D1 Submission: Design Concerns.

D1 Submission: More Concerns.

**Illustrative Masterplan
Figure 5.5F: Cable Corridor Option F**

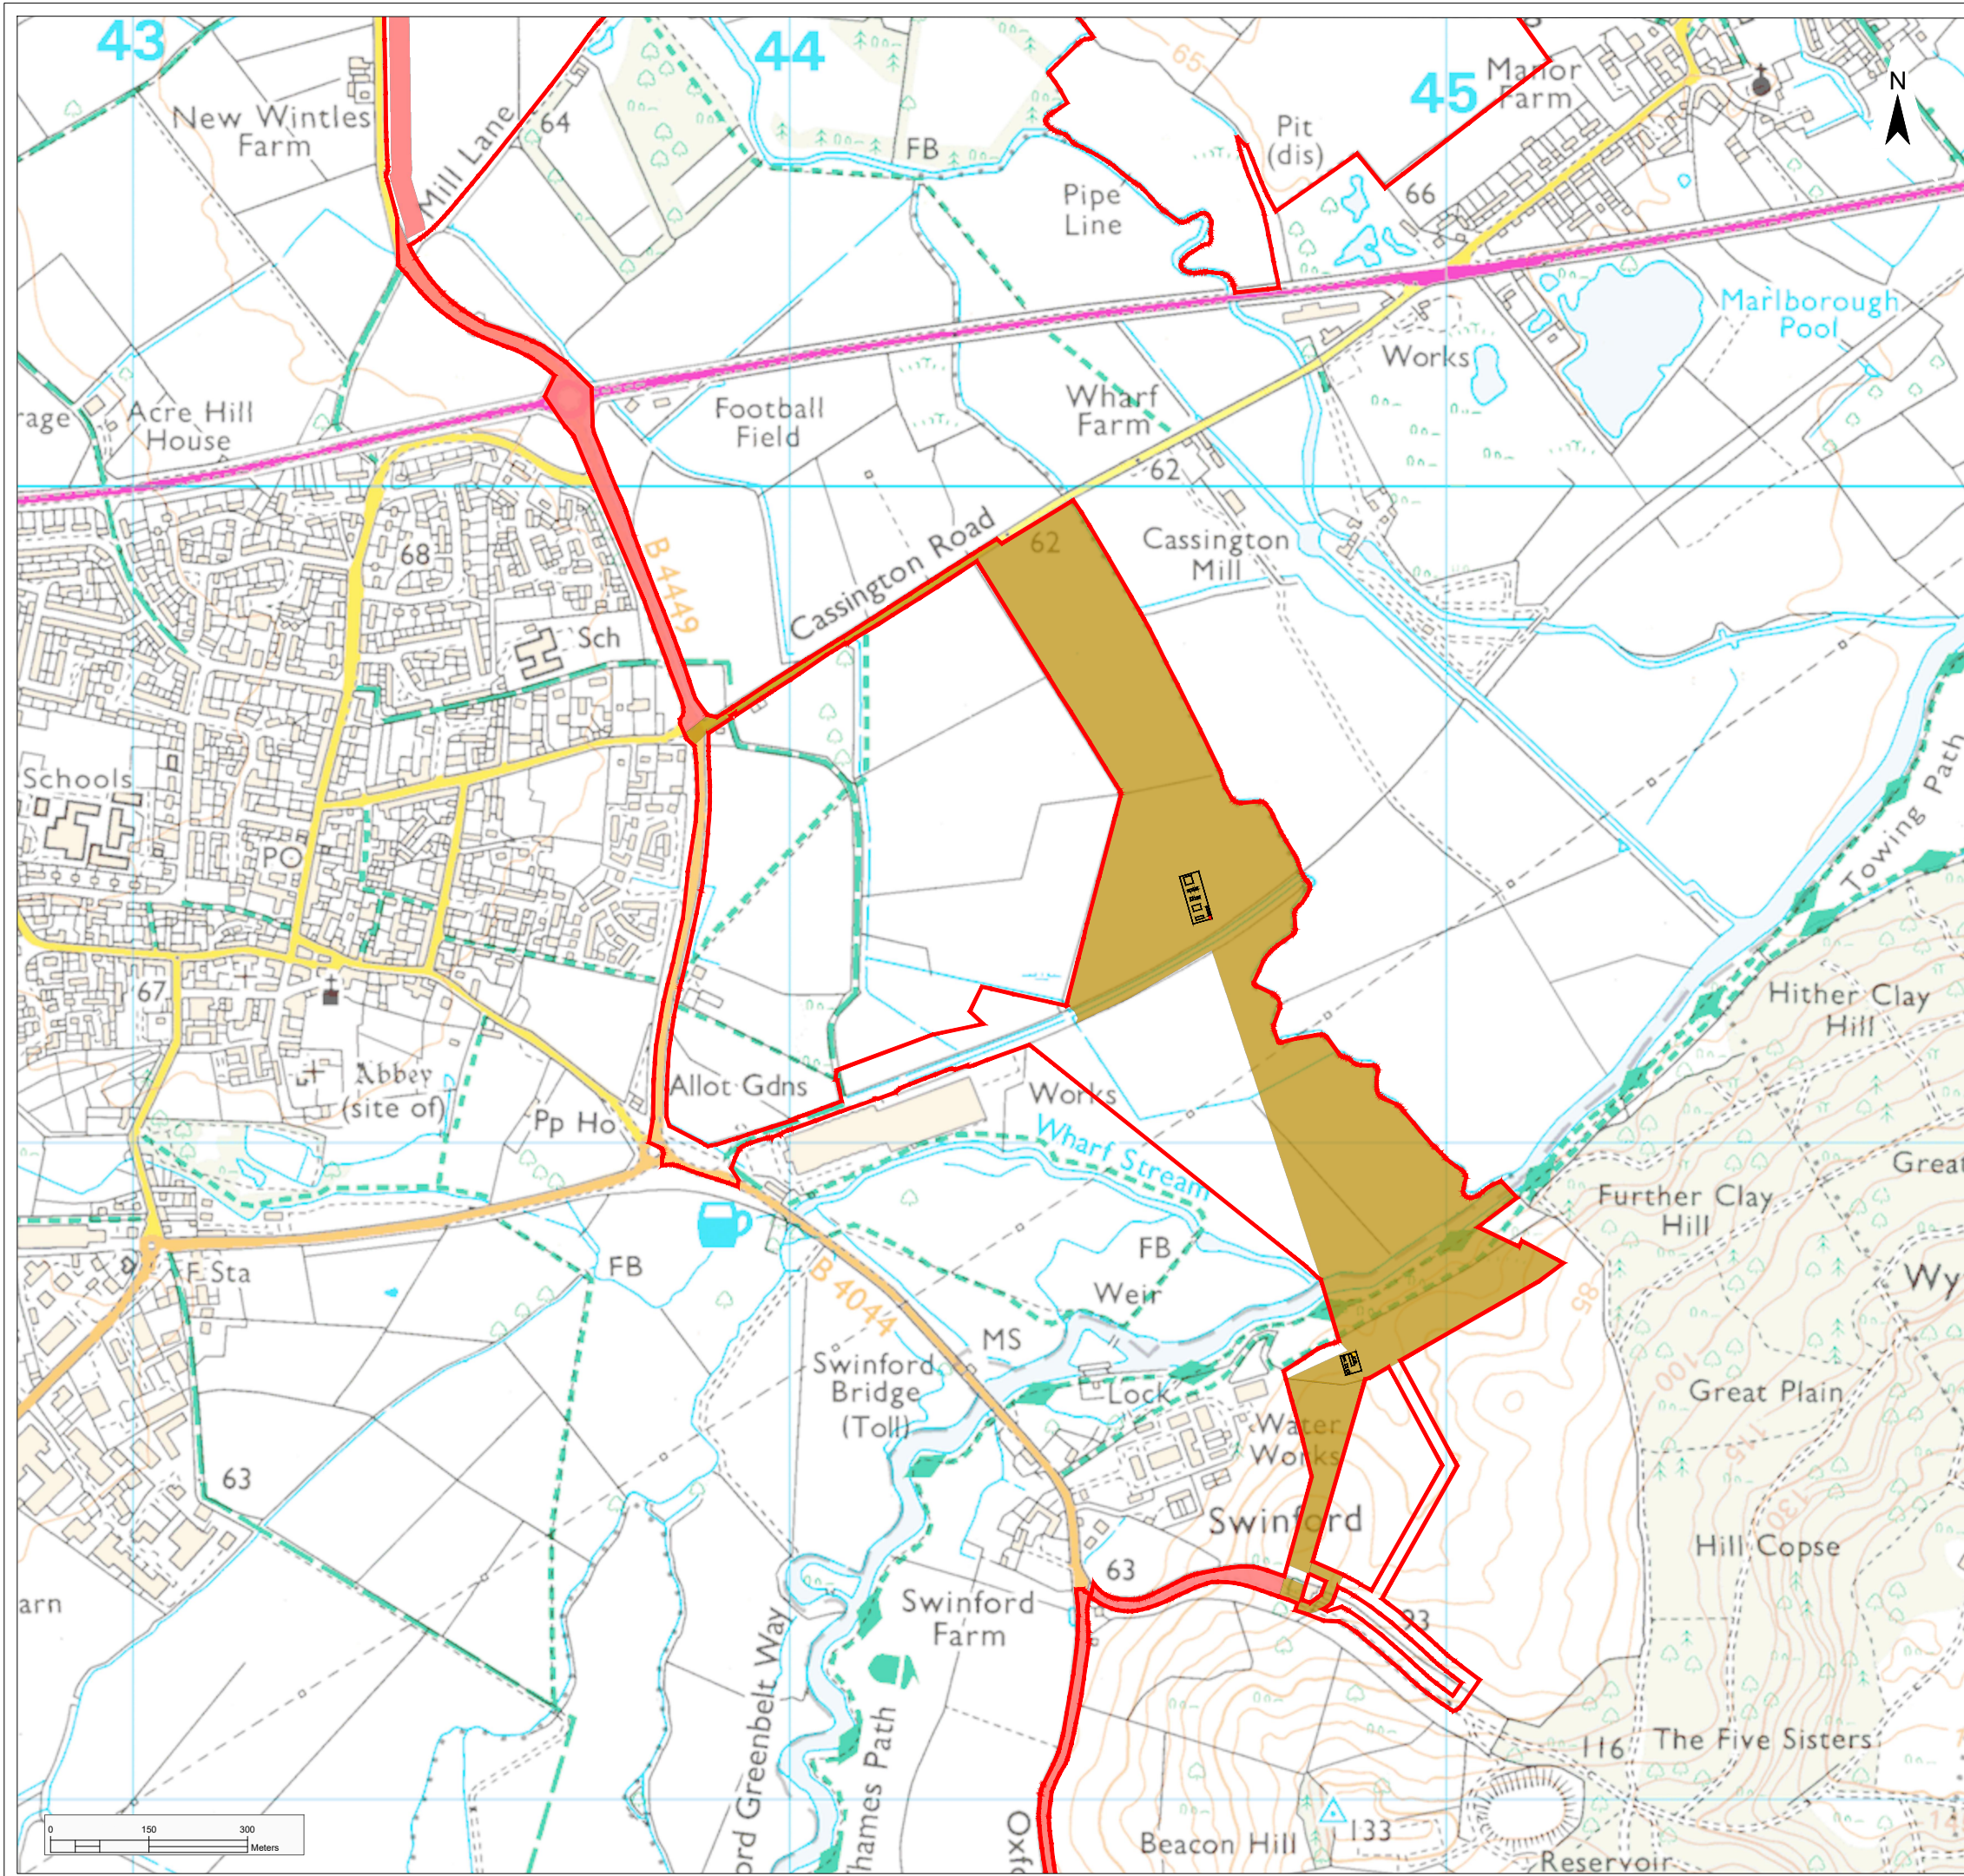
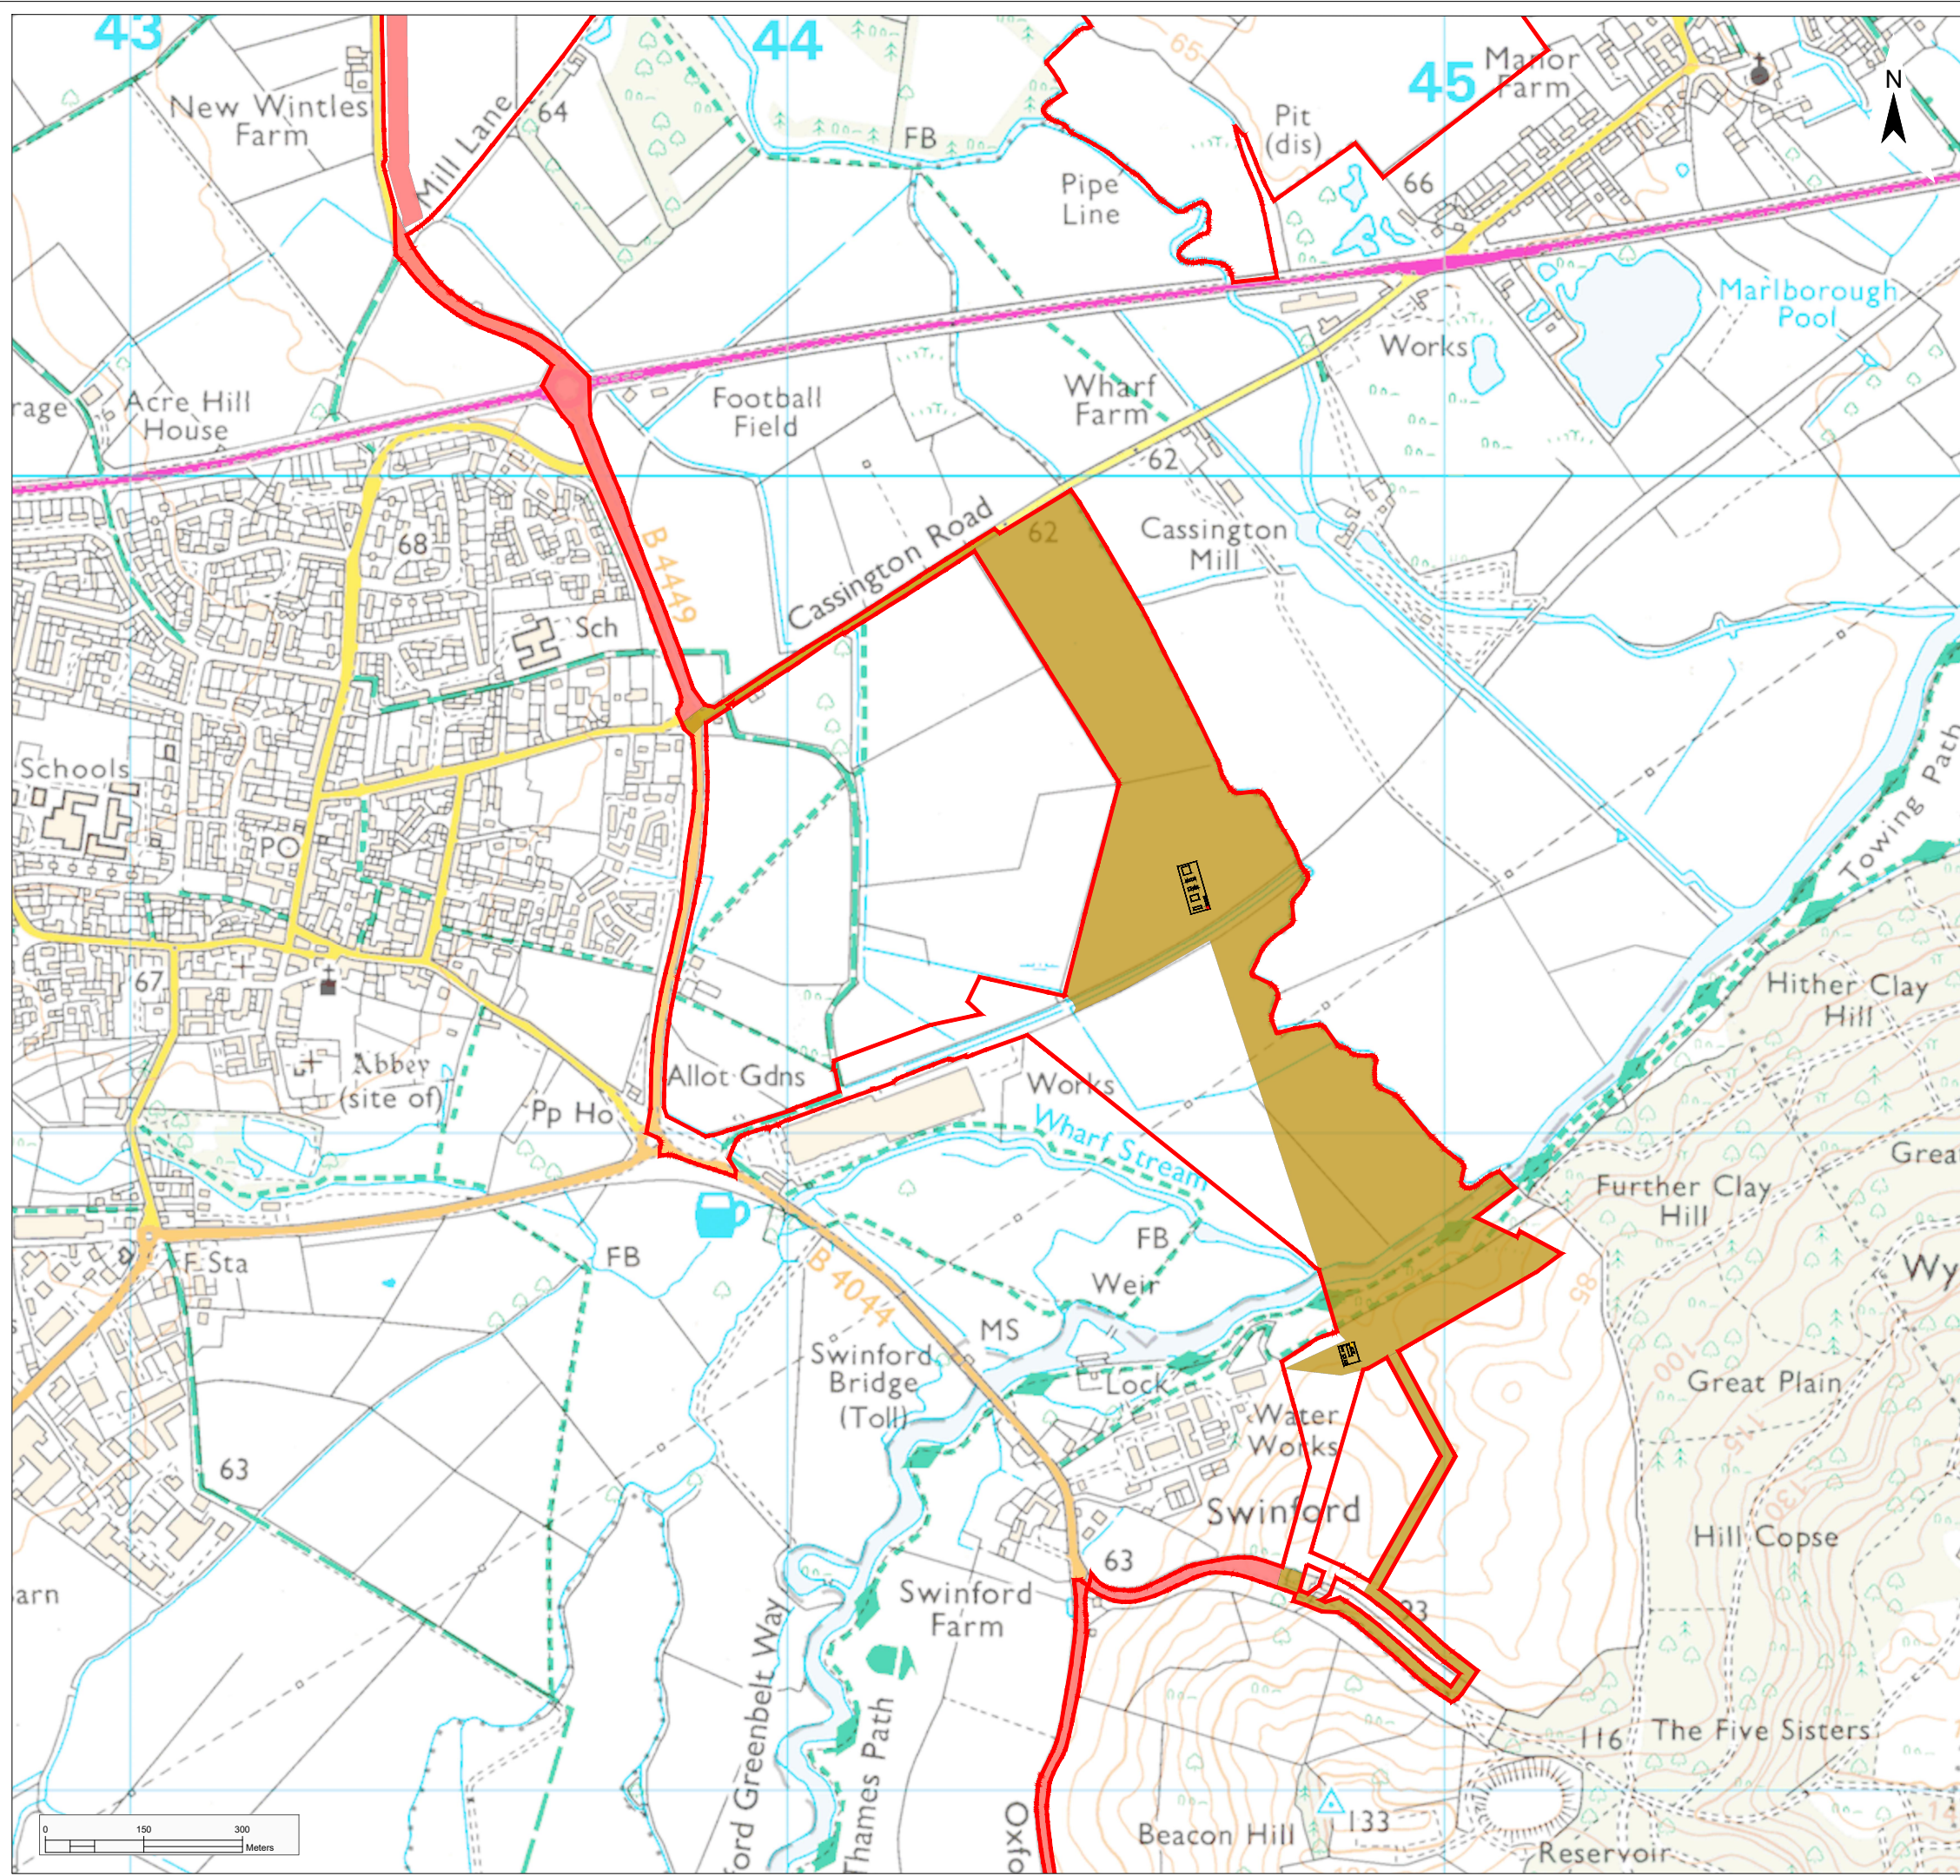
1) There are many ultra-short tables (e.g. **1** and **2** in the diagram). The Scoping Report gave a minimum table length of 14m. Project Description reduced this to 3m. Table **1** looks like a single panel width: 1m.

2) The Masterplan also shows the network of roads (**R**) than run around the perimeters and across the fields. These are coloured grey here but are described as 'grass with occasional matting' or 'natural ground surface' [[OOMP](#), p6]. Are these sufficient to support the weight of emergency fire tenders year-round? Has Oxfordshire Fire and Rescue been consulted? The roads look a bit narrow for the job (2.5m), and the turn radii are certainly far too tight to be negotiated by a fire tender. Should some panels be removed to relax the radii?

3) The north-south table gap is specified in Project Description as between 1.5m and 3.0m; the gaps measured on the Masterplan are 1.5m (panel:gap ratio 3:1).

4) Similarly, Table 6.3 of Project Description specifies a minimum distance of 7m between the fencing and the solar tables, whereas the Illustrative Masterplan shows PV panels consistently packed in with a fence separation of less than 5m.
